Application for a Non-Material Amendment Following a Grant of Planning Permission

Transport House

Removal of existing pitched roof and addition of a second floor to provide 2 x 1 bed and 1 x 2 bed residential units

17502/APP/2020/4148

SCALE	1:100 @ A3	DRAWING NUMBER	REV.
DATE	JUL 2020		
DRAWN	BM	1134-04	E

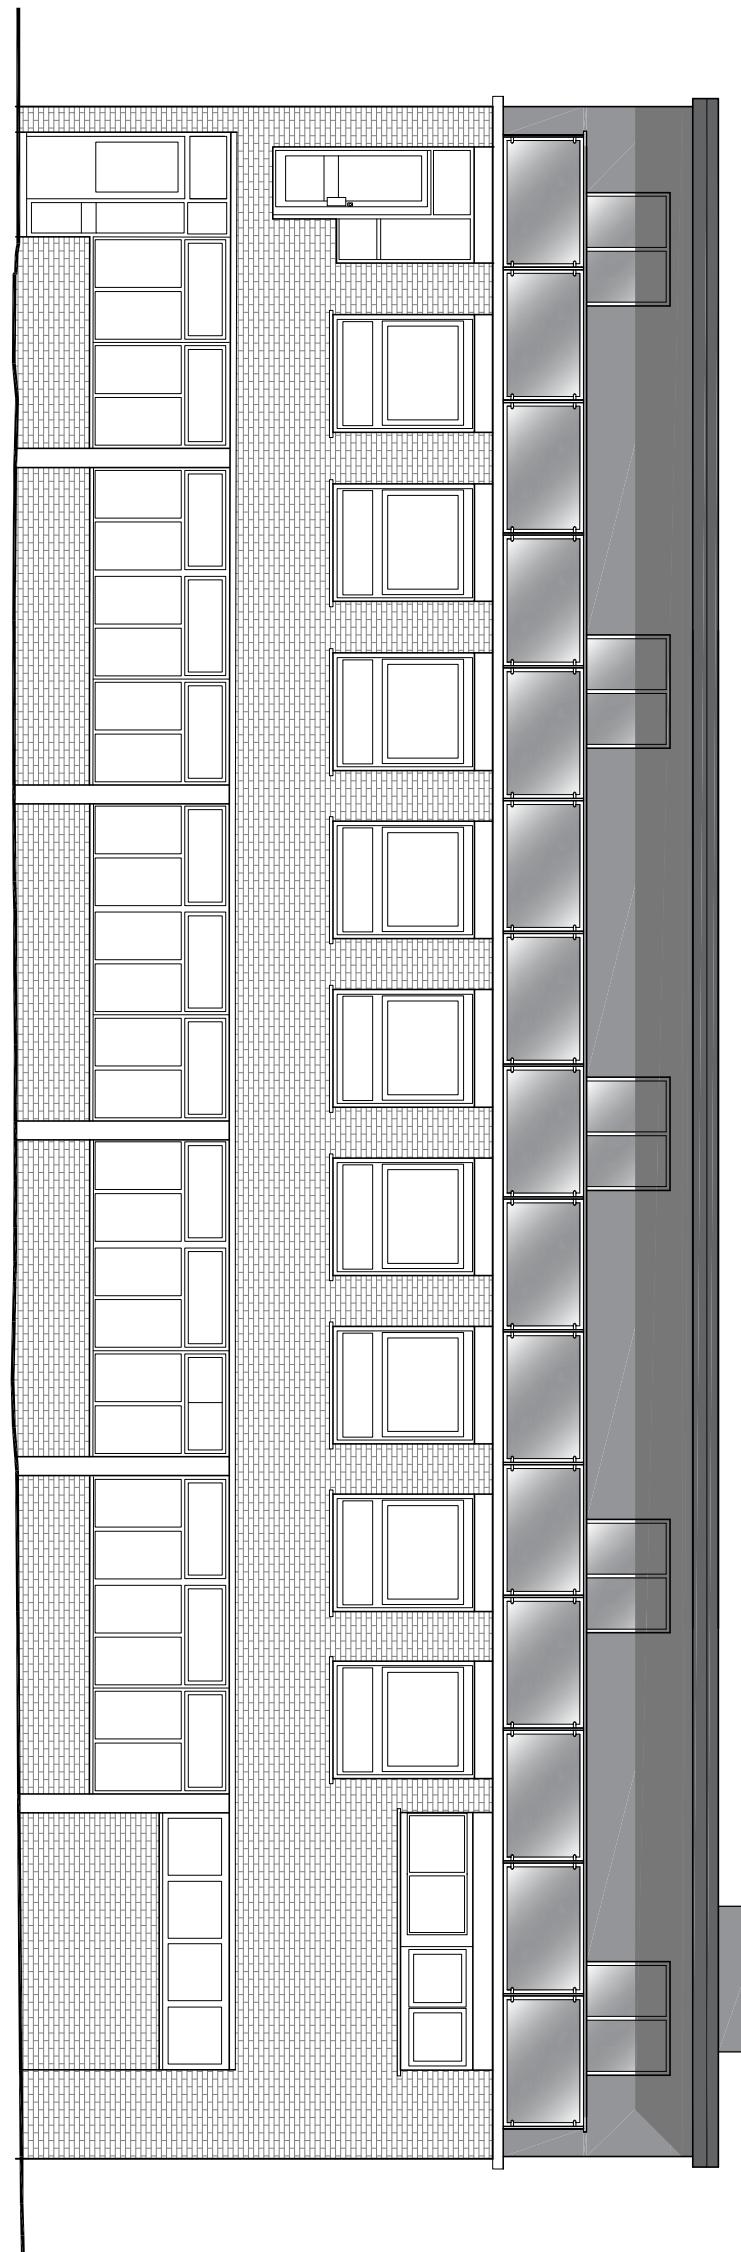
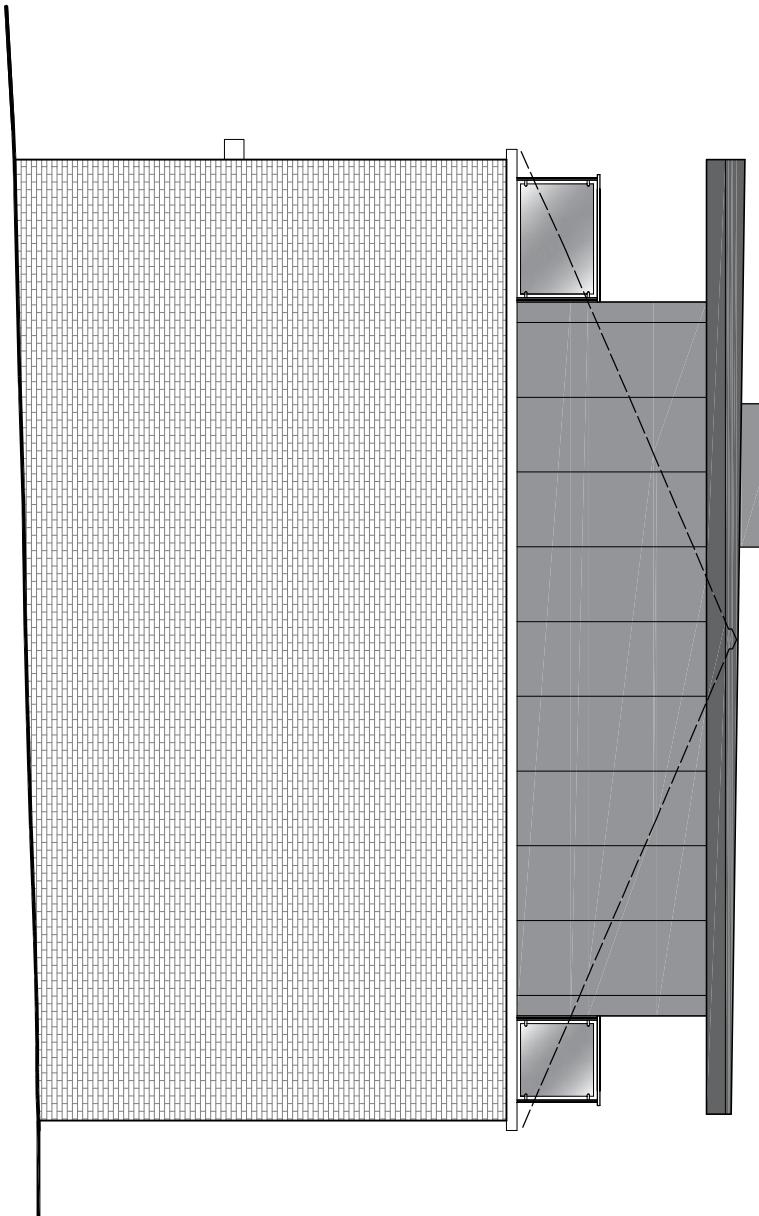
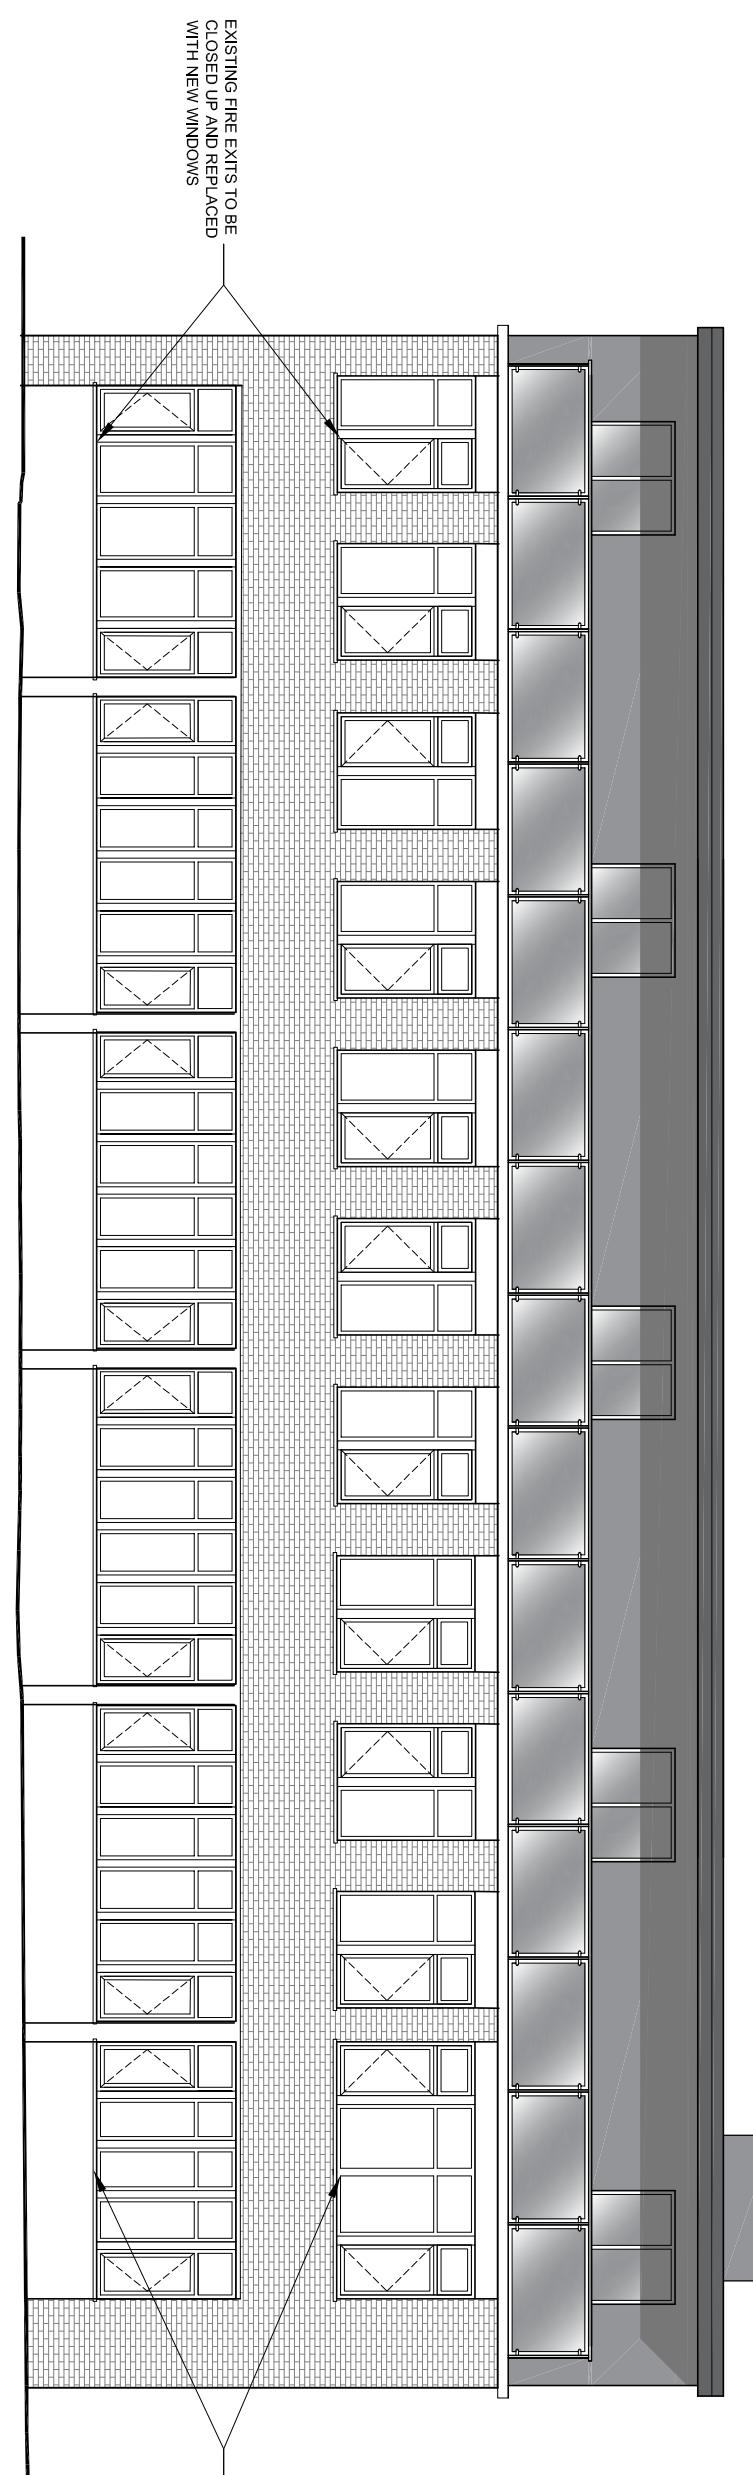
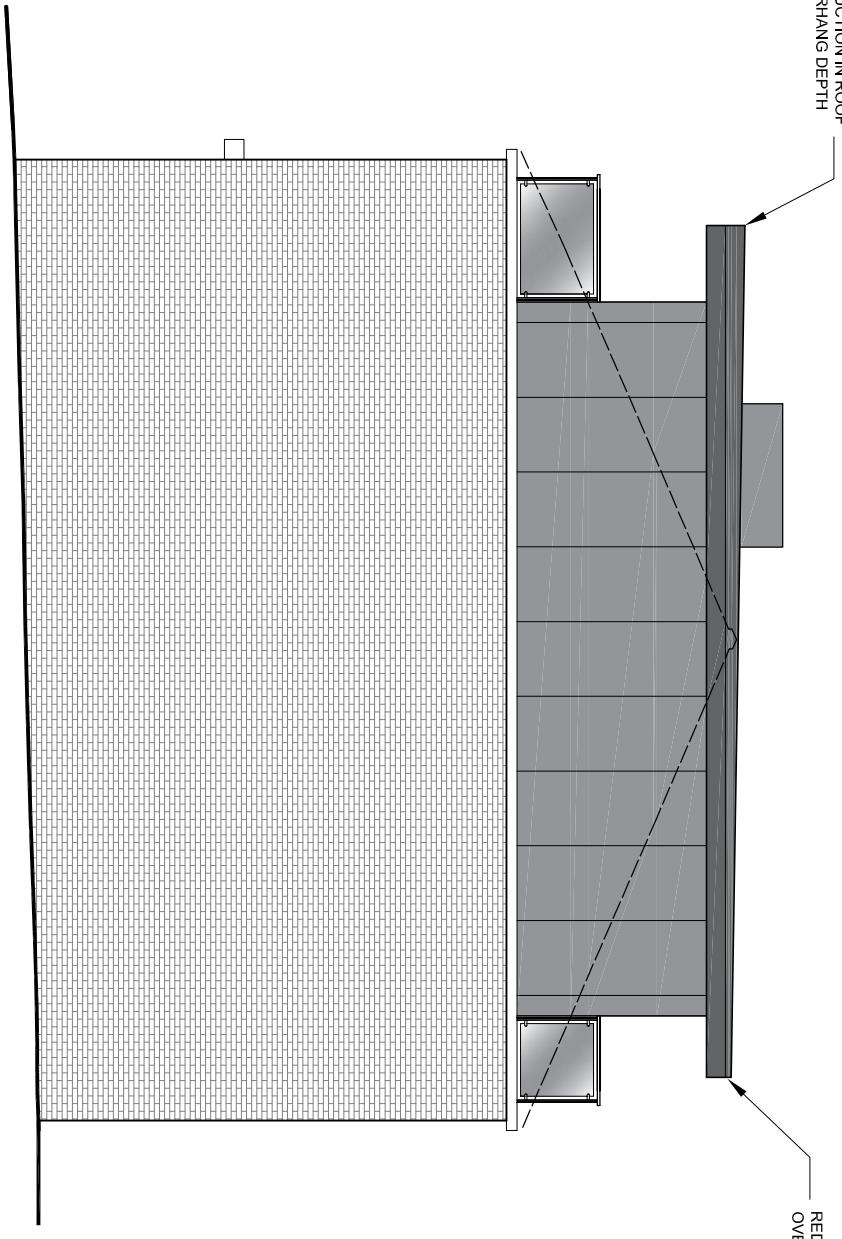
The original office toilet windows are at high level and need to be lowered to provide suitable amenity for the residents of the new flats.
The emergency exits are also no longer required.
The existing windows throughout are old white UPVC and need to be upgraded to current U-Values and to achieve required acoustic levels.
The new replacement windows shall be grey UPVC to match the approved windows and doors on the new top floor.
The proposed roof overhang is being reduced slightly at the front and rear of the building due to structural concerns over forming the overhangs to the depths shown on the approved plans.

1134-3E and 1134-04E
